**Re: *Bunting Multifamily Site Development Plan, PPR-17-037, Review 1 Response***  
***MVE Project No. 61072***

M.V.E., Inc. has prepared the following response to comments contained in your September 20, 2017 comment letter concerning the above named project. Revised submittal materials are enclosed as needed. Each comment is addressed below in the order contained in your comment letter.

SITE PLAN

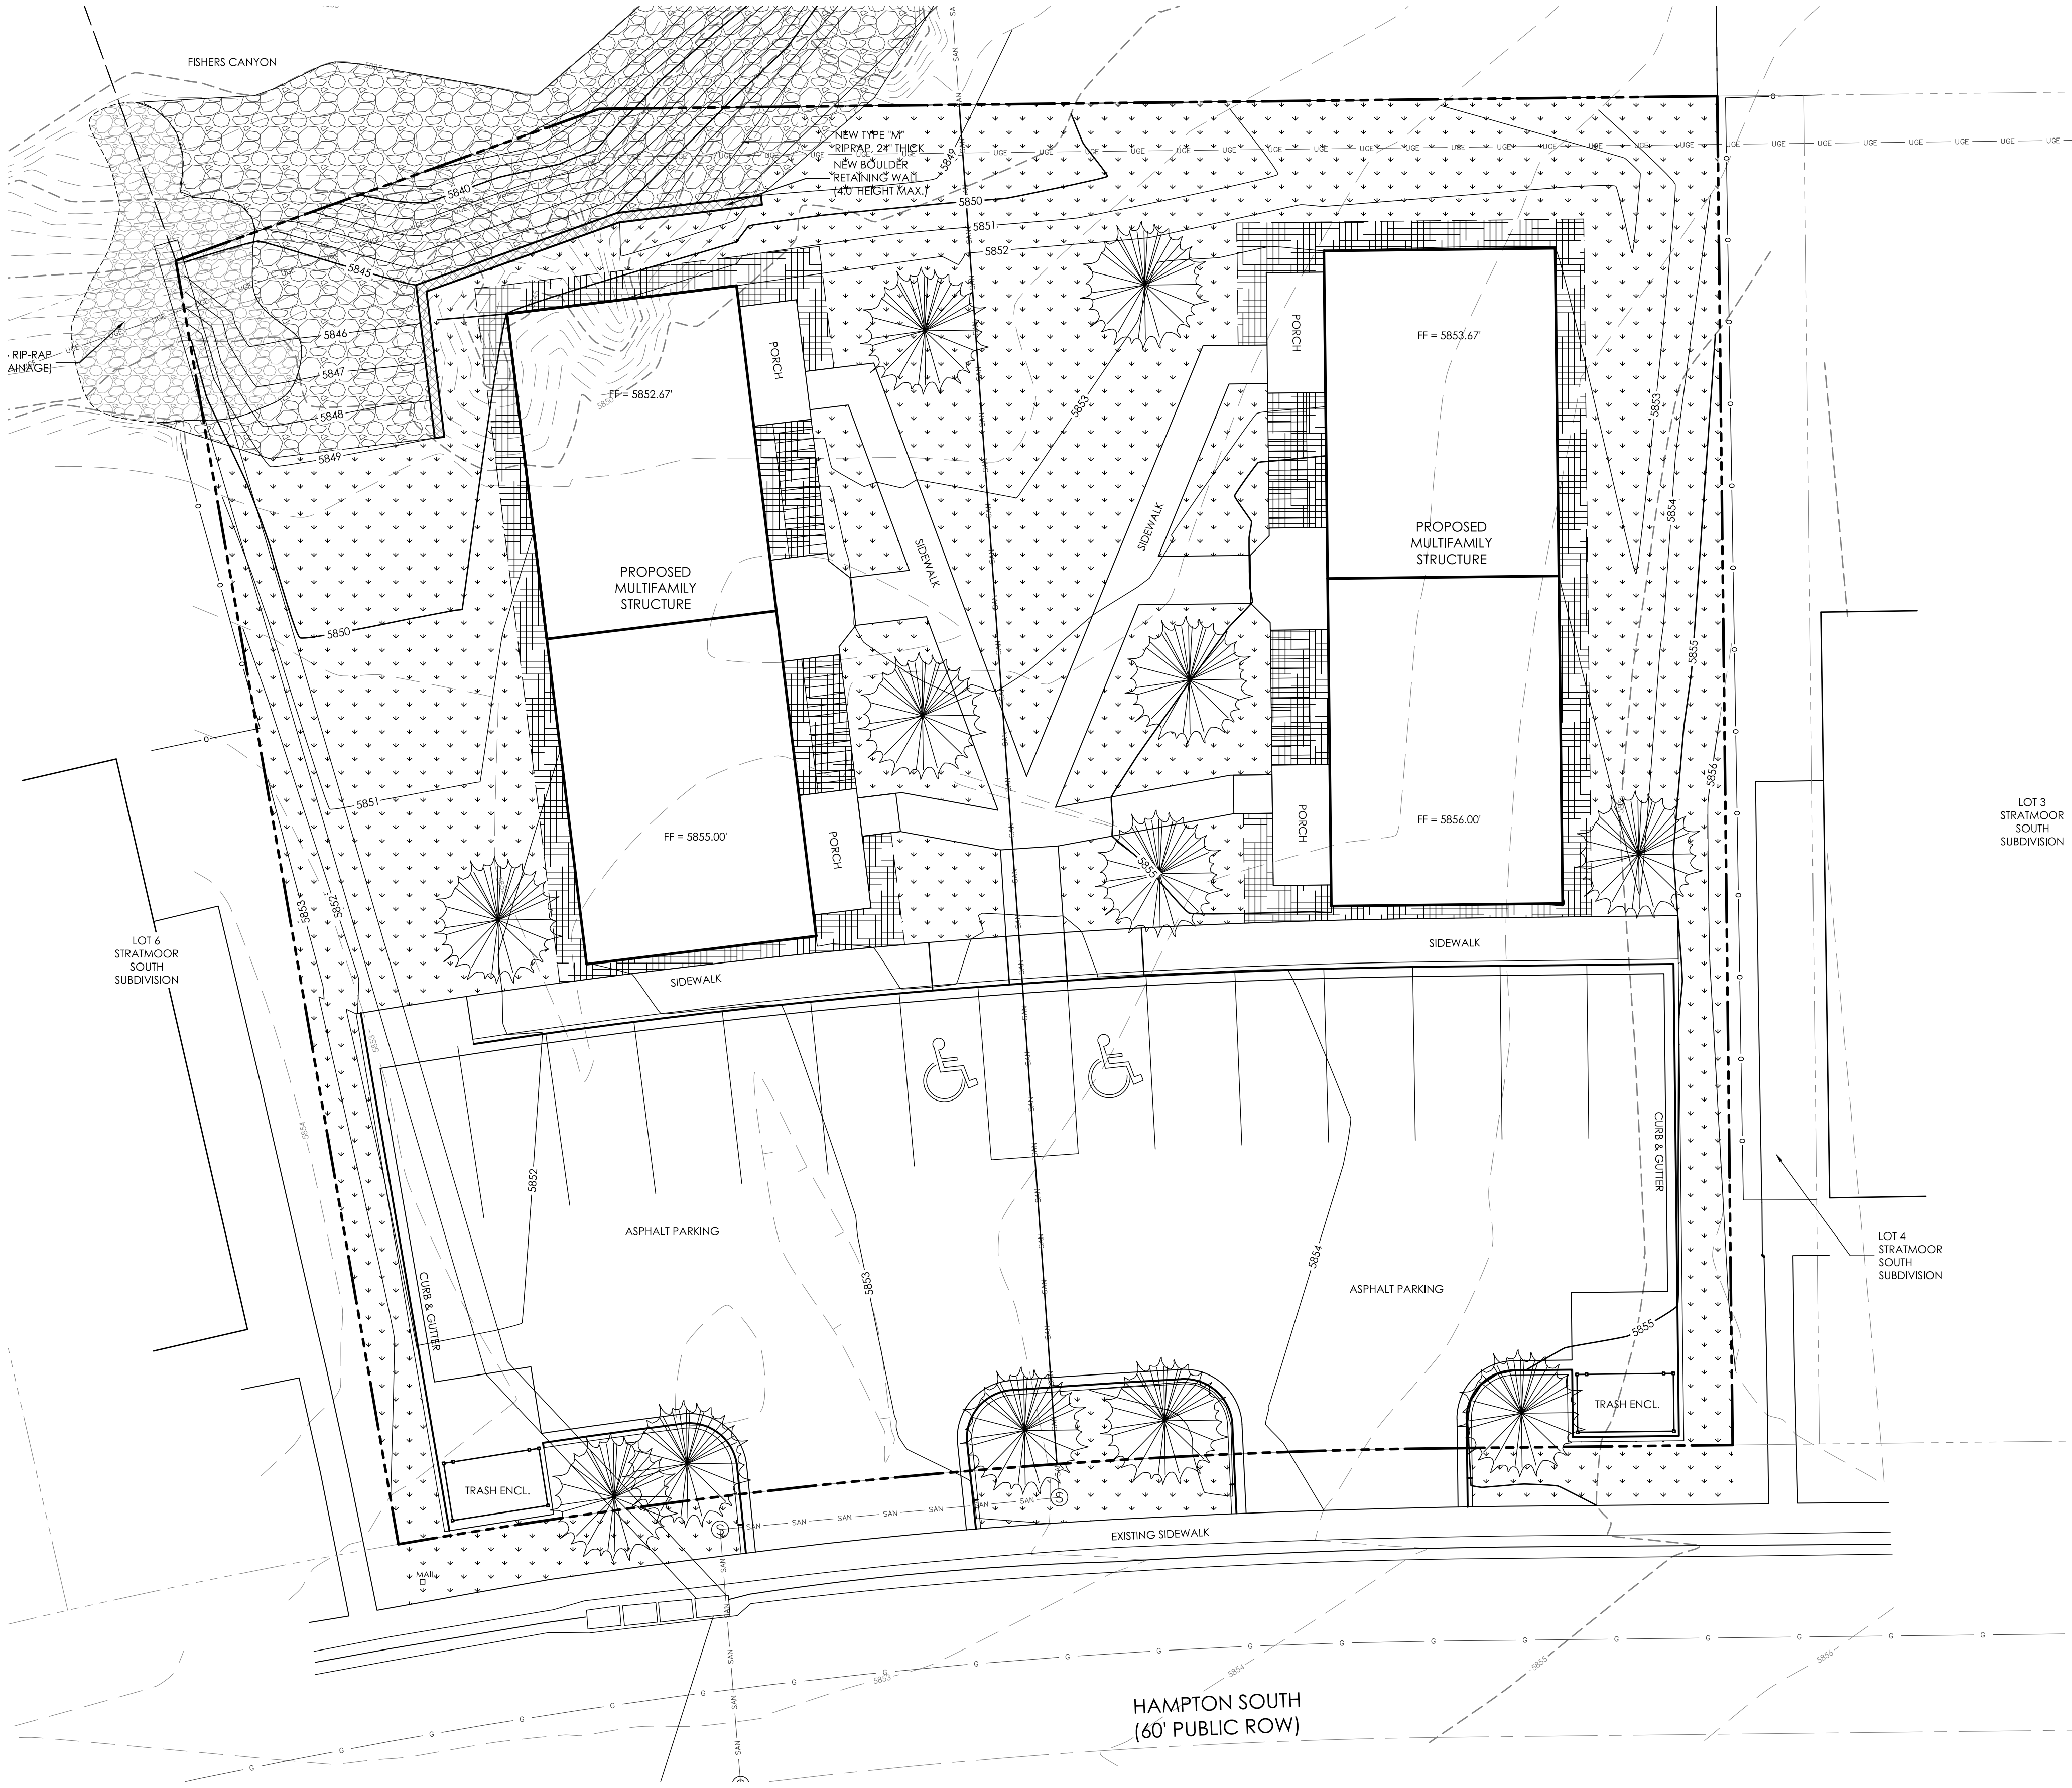
1. *Provide a separate utility sheet. Show and label existing gas and electric and proposed gas and electric services. Response: A utility sheet has been added.*
2. *Show and label all applicable easements with width and Reception No. Response: Requested information has been added.*

*The properties have an 8 inch sewer main that runs down the center property line as well as there being 2 man holes on the front of the lot. Right to the east of the storm drain. We will need*

*to verify easements and require that nothing be built over this sewer main. I have included a revised drawing with the approximate location of said sewer lines. 719-649-8953 If there are any questions. Thank you, Nancy Lee Watkins* **Response:** The plans have been revised with this information and field surveyed locations.
